PLAN SNAPSHOT REPORT MINOR_PLT-2026-00011 FOR CITY OF ALBUQUERQUE

Description: Request preliminary / final review of our Minor subdivision plat to create 1 new lot from the 8 existing parcels. Plat also requests a DHO determination to allow the sidewalk along Zuni to remain as-is at 5.4 feet wide. Cardenas Drive's 3.5 ft wide sidewalk is to be widened.

Re: Preliminary / Final Plat for Proposed Minor Subdivision Plat for Lots 1 thru 4 and portions of Lots 21 thru 24, in Block 3 of Baron Burg Heights Addition

Drawing file: PR-2025-020125_PA-2025-00330_October_22_2025 (Sketch) / Scale drawing of proposed Plat-Site Plan-2025-10-13-191835_PLAT_v1.pdf

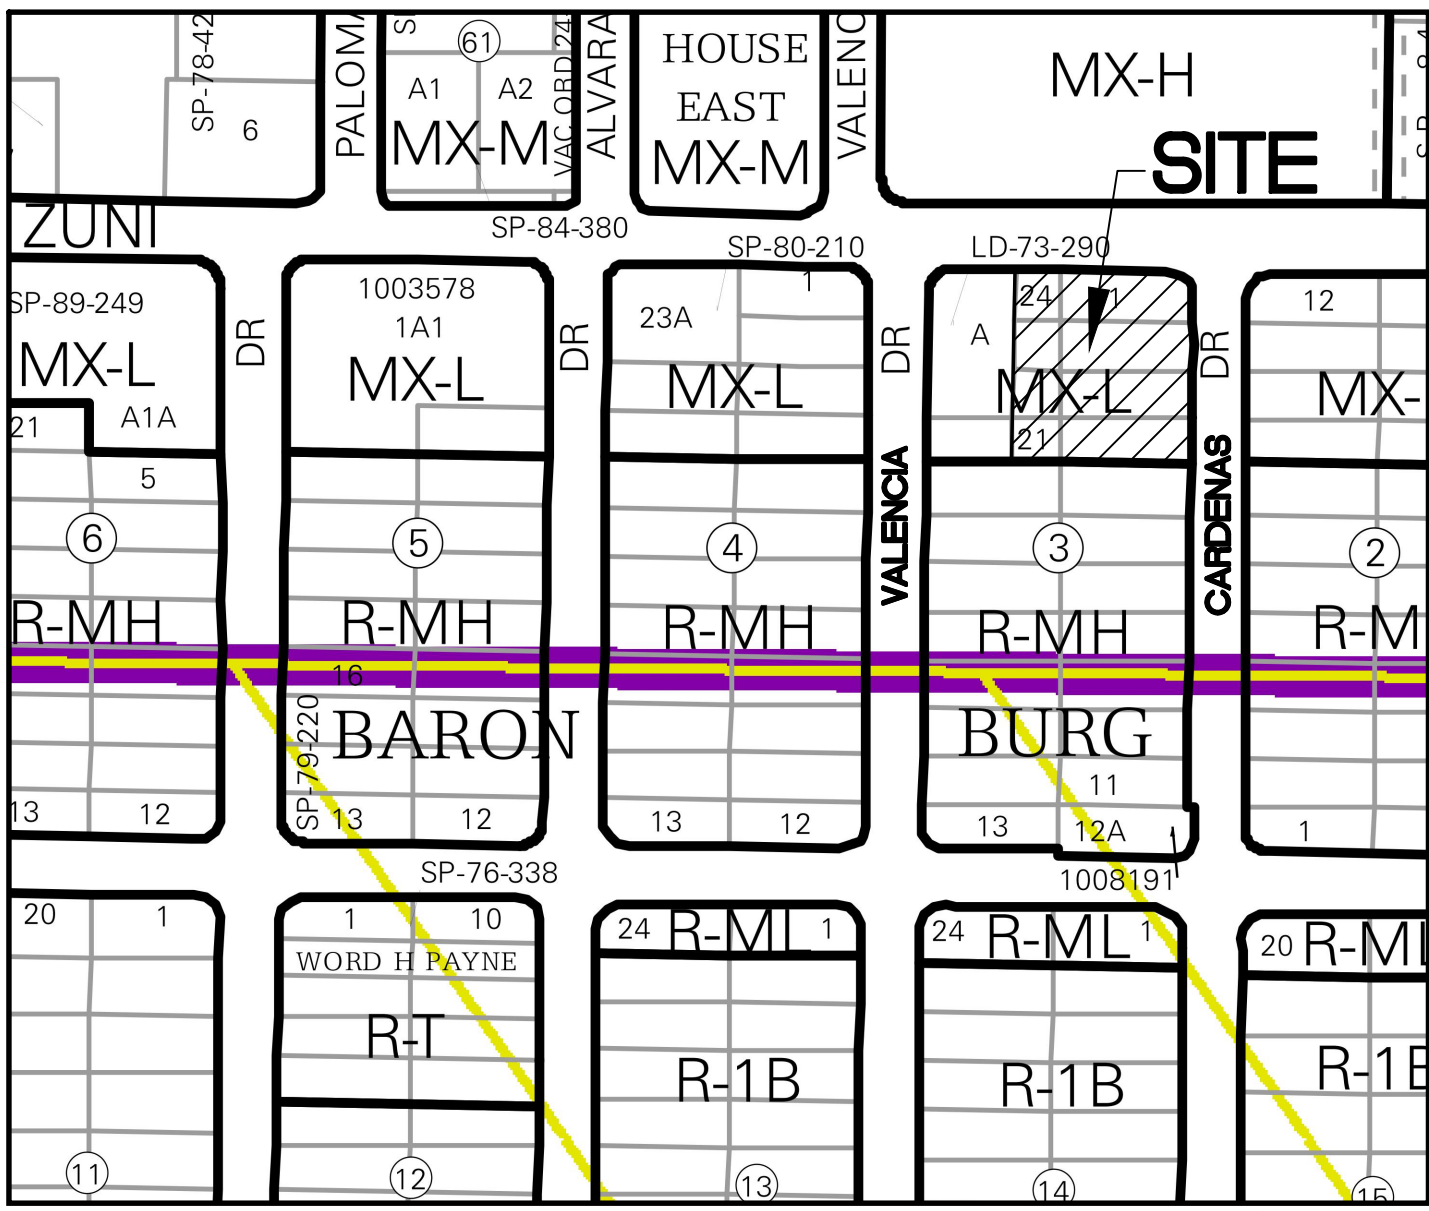
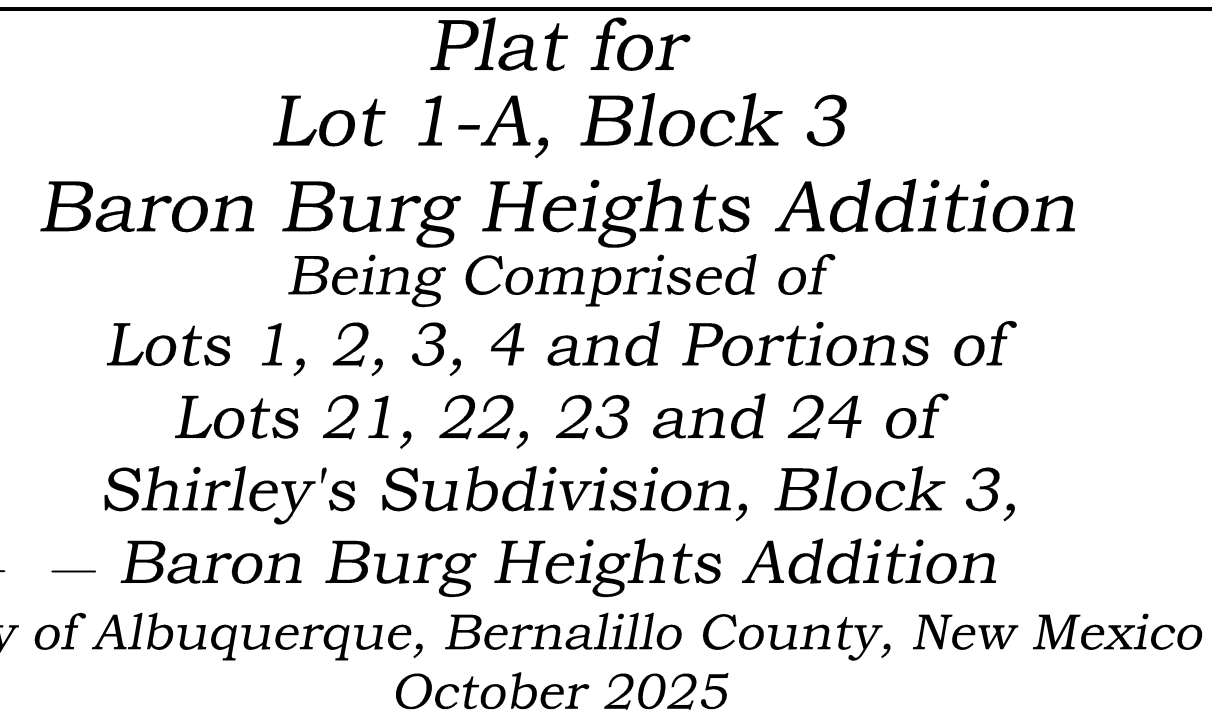
1. Please add this note to the plat:

a. "Existing public water and/or sanitary sewer infrastructure may not be constructed or sized to adequately serve potential future development. Improvement or upsizing of existing public infrastructure may be required as a condition of future development approval."

Noted, see note number 5 on page 1 of our proposed plat.

**Plat for
Lot 1-A, Block 3
Baron Burg Heights Addition
Being Comprised of
Lots 1, 2, 3, 4 and Portions of
Lots 21, 22, 23 and 24 of
Shirley's Subdivision, Block 3,
Baron Burg Heights Addition
City of Albuquerque, Bernalillo County, New Mexico
October 2025**

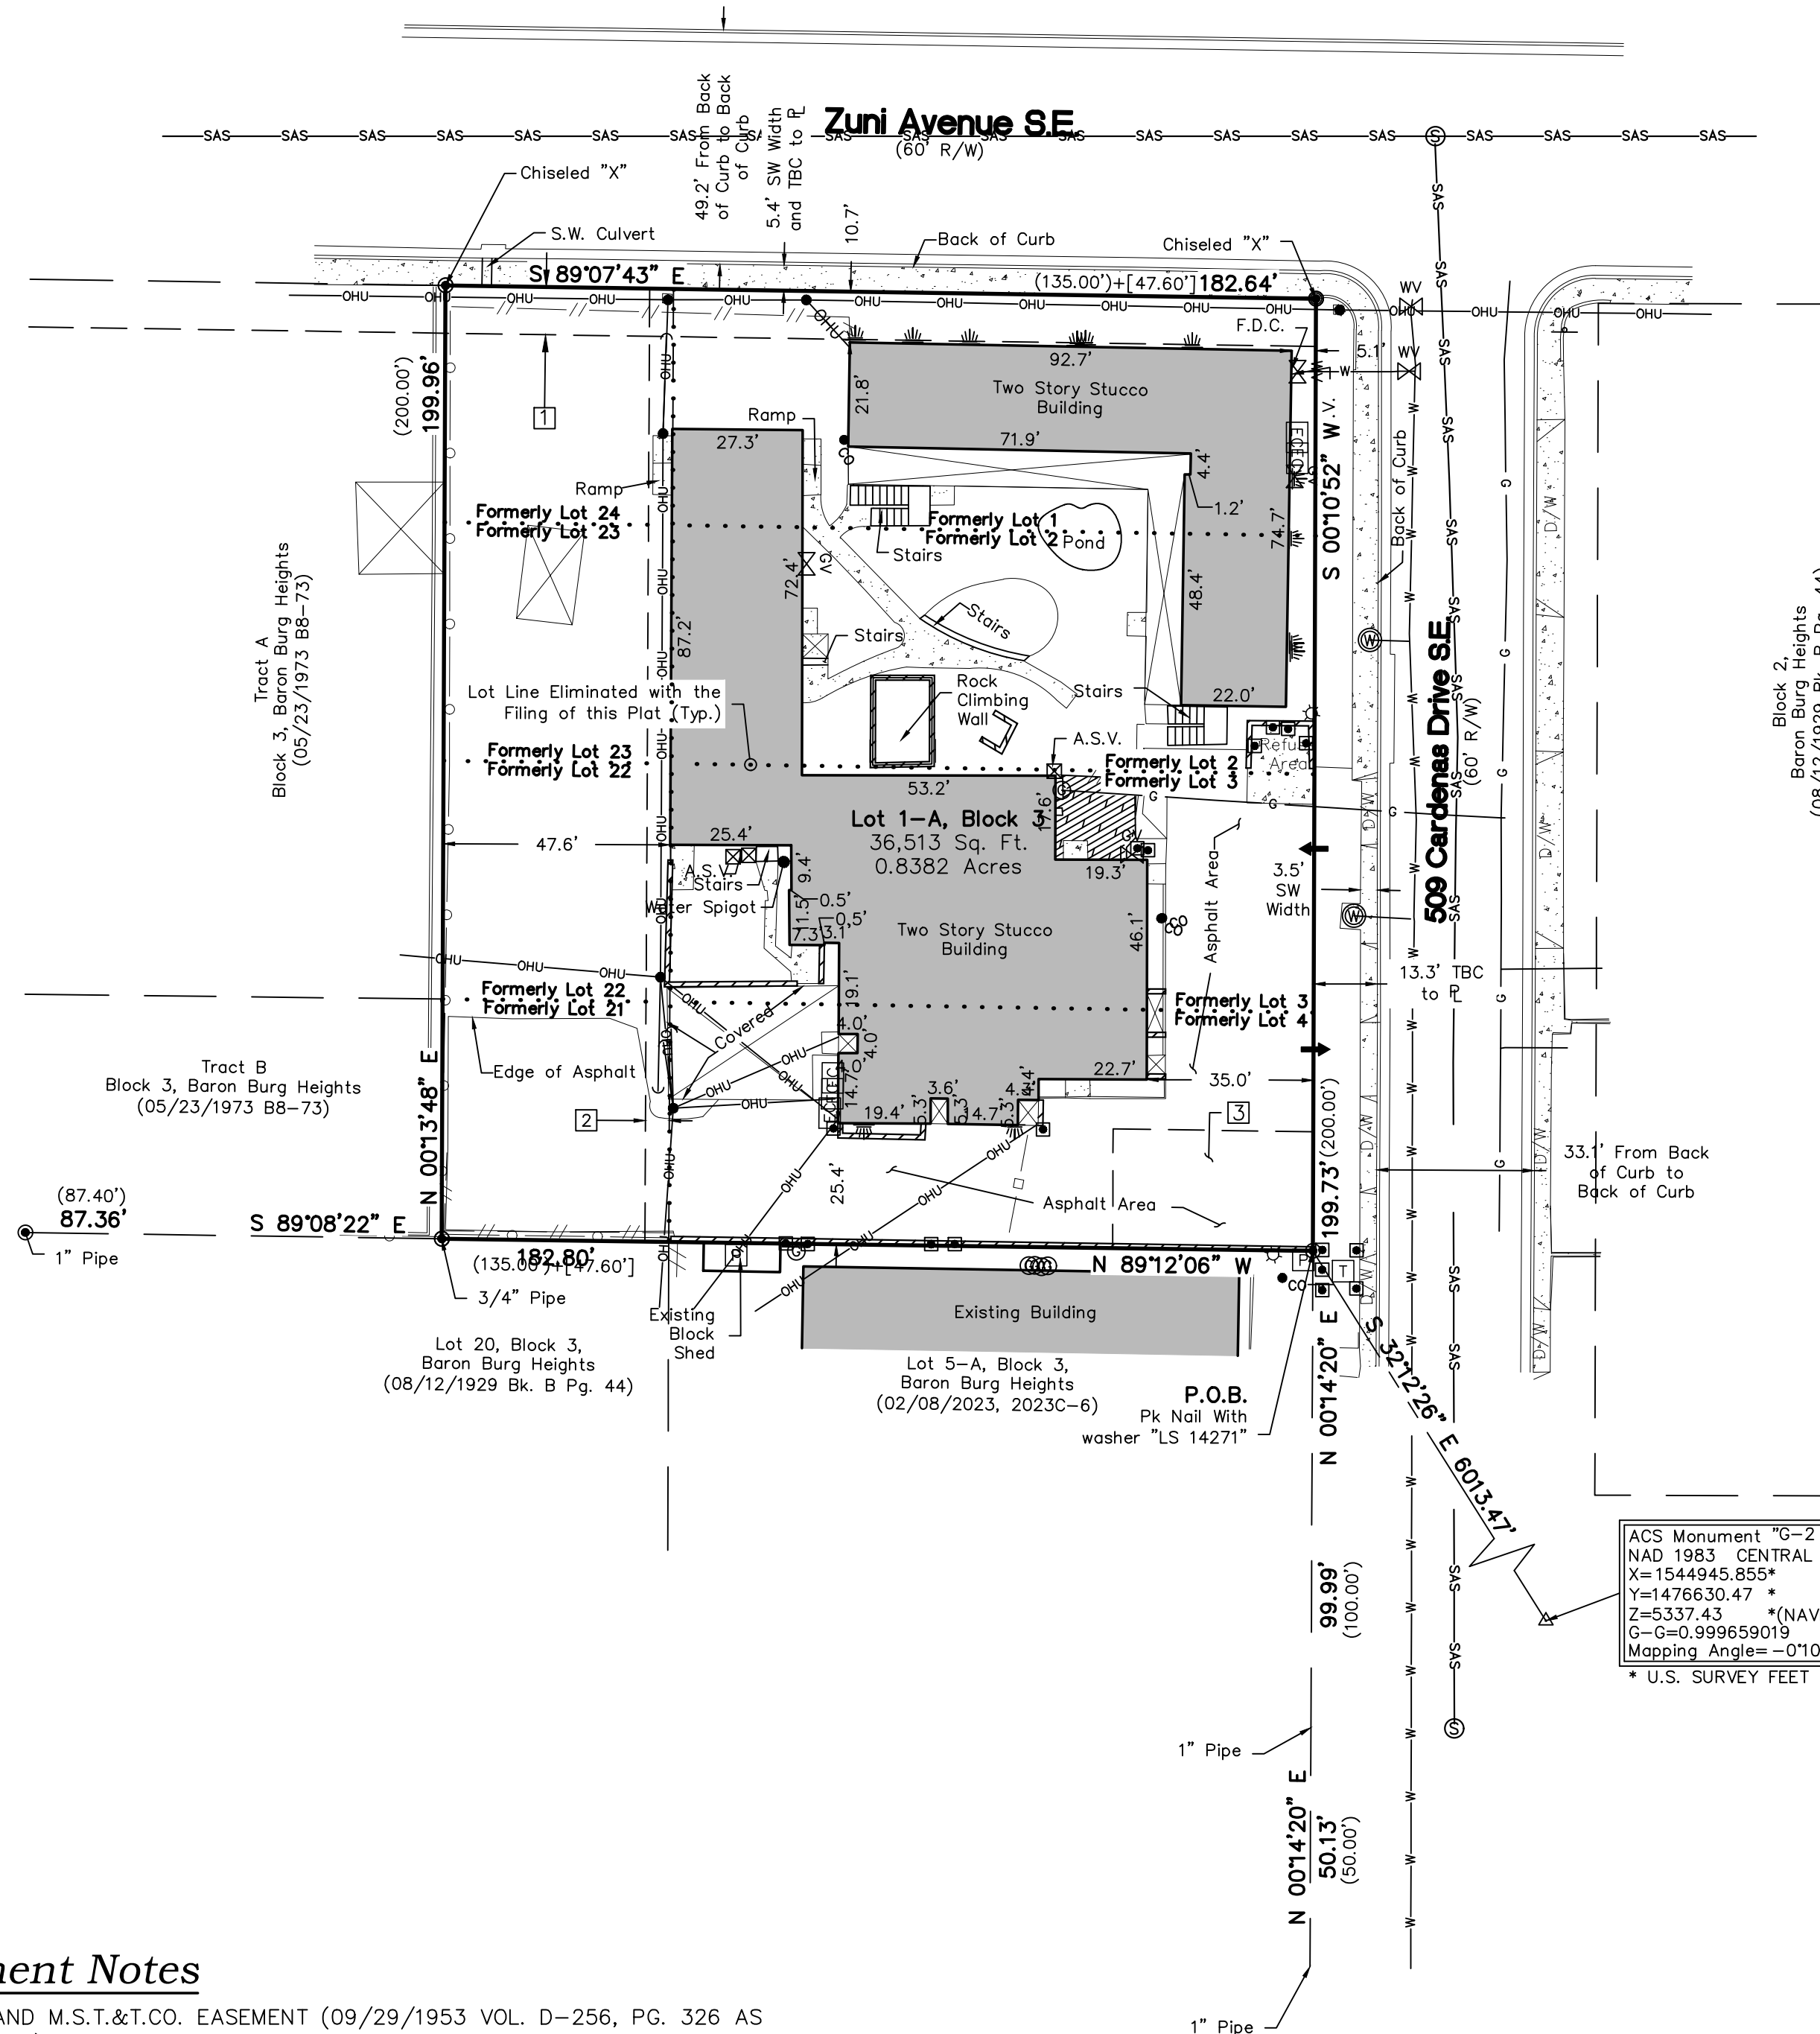
1. Zuni is principal arterial requires 6' sidewalk and 5'-6' Landscaping Buffer. Cardenas is local street requires 5' sidewalk and 4'-6' Landscaping Buffer. your drawing show sidewalk width of 5.4' along Zuni and 3.5' along Cardenas, both sidewalks need to be widened.

♣ Demonstrate compliance with Section 7 of the DPM, Table 7.2.29, regarding Sidewalk width requirements and its landscape buffer. Zuni Road SE is a Principal Arterial Street and requires a 6' sidewalk with 5' to 6' landscape buffers. Cardenas Drive is a local street and requires a 5' sidewalk width and 4-6 ft landscape buffer.

Noted, see infrastructure list for sidewalk widening along Cardenas and justification letter for request for determination from sidewalk widening along Zuni Rd SE. IIA is expected for Cardenas sidewalk.

Noted, see Transportation comments and DHO determination justification for Zuni in application materials.
